RE: Interim Audit Advice Letter No.2 - Response to SSDA Comments, 49-61 Stephen Road, Banksmeadow NSW

Application for State Significant Development (SSD) 65924461 has been made for Remediation of site and construction and operation of a multi-level warehouse.

As requested by ESR, this Interim Audit Advice No. 2 (IAA2) has been prepared to provide a response to comments made by Department of Planning, Housing and Infrastructure (DPHI) on SSD-65924461.

Ref 318002013
Audit No. RS-187

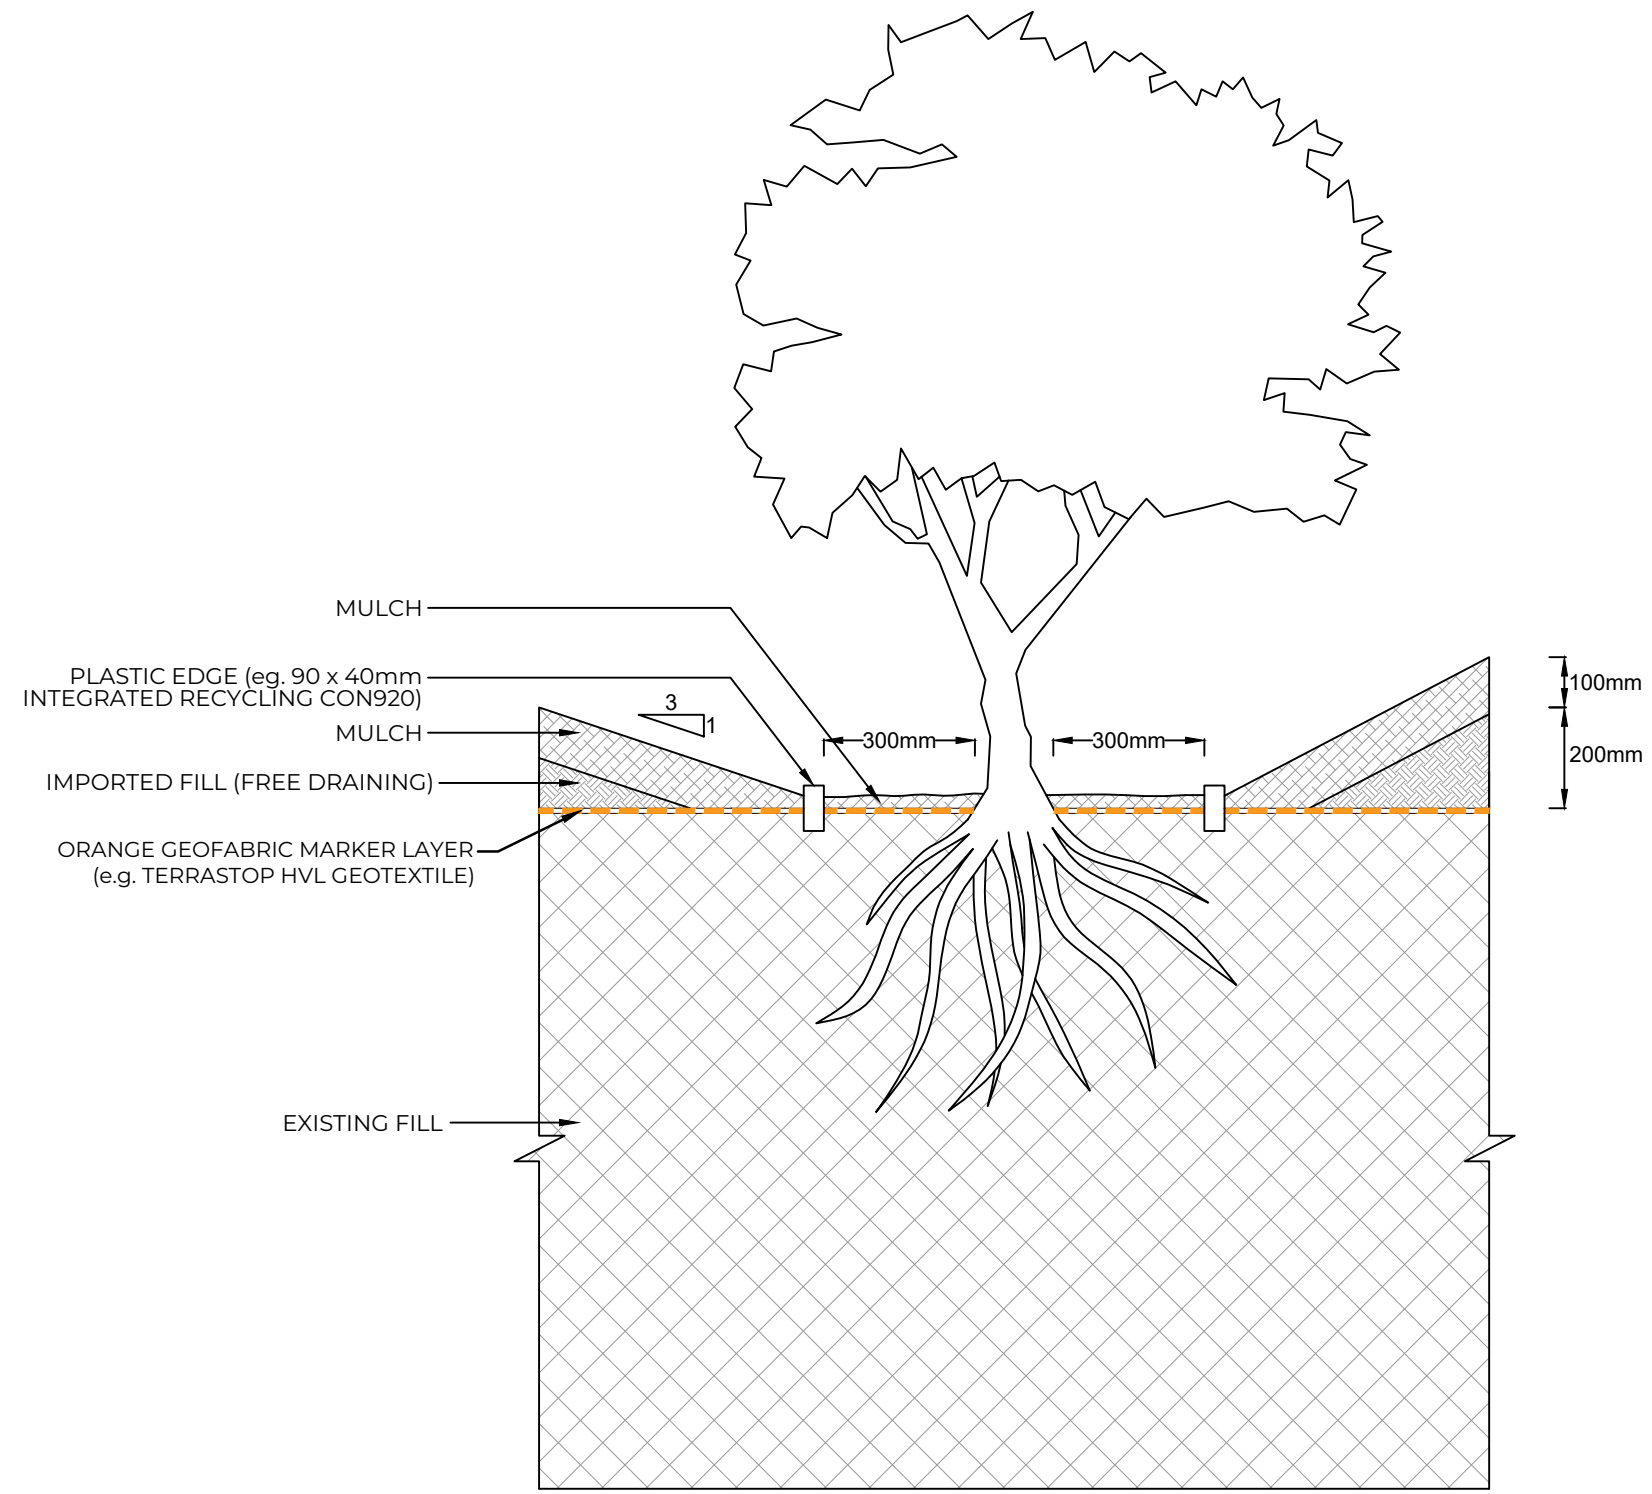
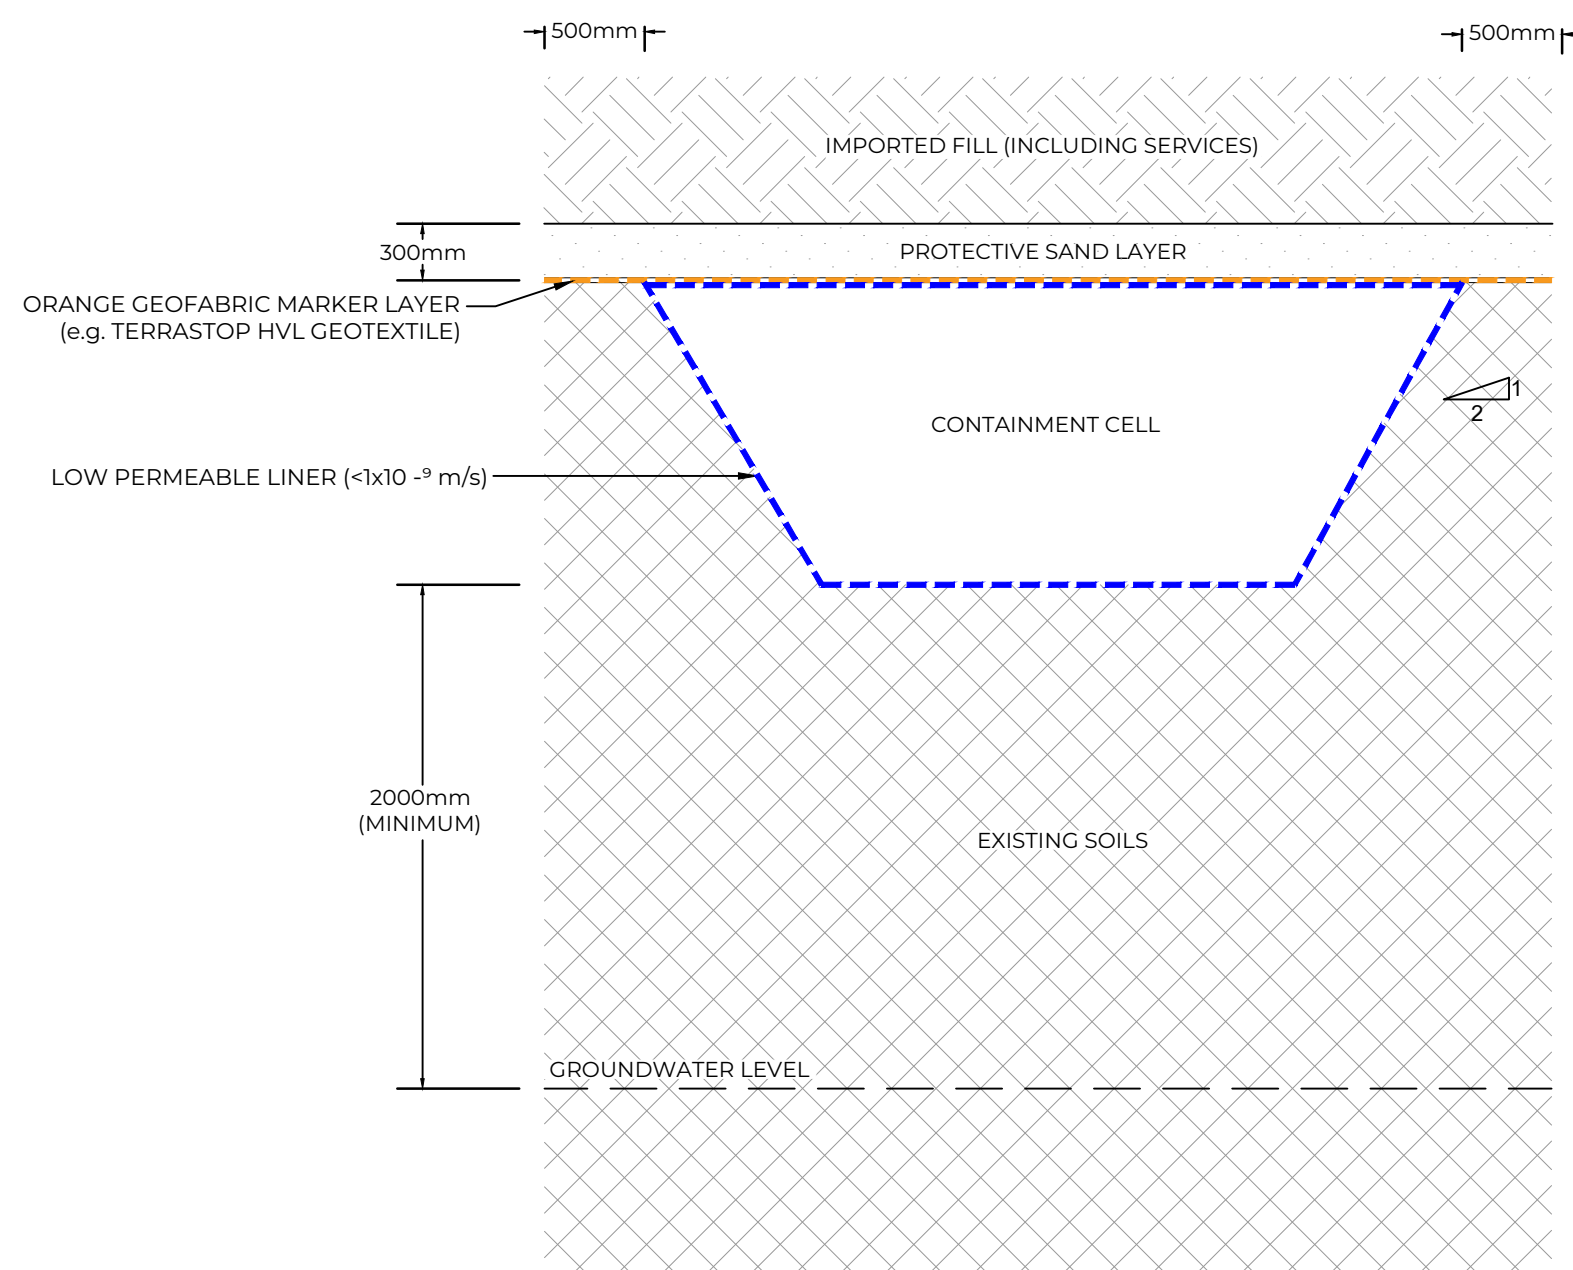
DPHI Comment Topic	DPHI Comment	Summary of DP Response	Auditor Comment
Containment Cell (Point No. 1)	<i>The Remedial Action Plan (RAP) proposes placing soils containing organochlorine pesticide concentrations exceeding the remediation criteria within a containment cell. Additional information is required to clearly define the location and design of the proposed containment cell, its relationship to the overall development, and to provide written interim advice from the Site Auditor confirming acceptance of this approach.</i>	Containment cell design, including dimensions and location, will be finalised with the development design, in particular in consideration of design of piling and inground services. The Rev 1 RAP (Section 10.2, Section 11.2 and Drawing 12) outlines parameters and requirements to be met to achieve the required remediation outcomes. An outline of the RAP requirements in relation to the containment cell is provided in the DP response. In summary, the containment cell will hold about 3,000 m³ of contaminated soils with contingency, be constructed below a capping and marker layer, include groundwater separation, use a low permeability liner, and likely be located in the north-eastern site area. The DP Response also includes a more detailed discussion of potential volumes and potential containment cell dimensions.	The proposed containment cell approach is considered acceptable. The level of detail included in the RAP for the containment cell design is considered appropriate for the current planning stage. The RAP notes that additional documentation is required to be prepared including final development design, structural piling design, containment cell design. Relevant additional documentation will be reviewed during the course of the Audit and will be subject to Auditor approval prior to implementation.
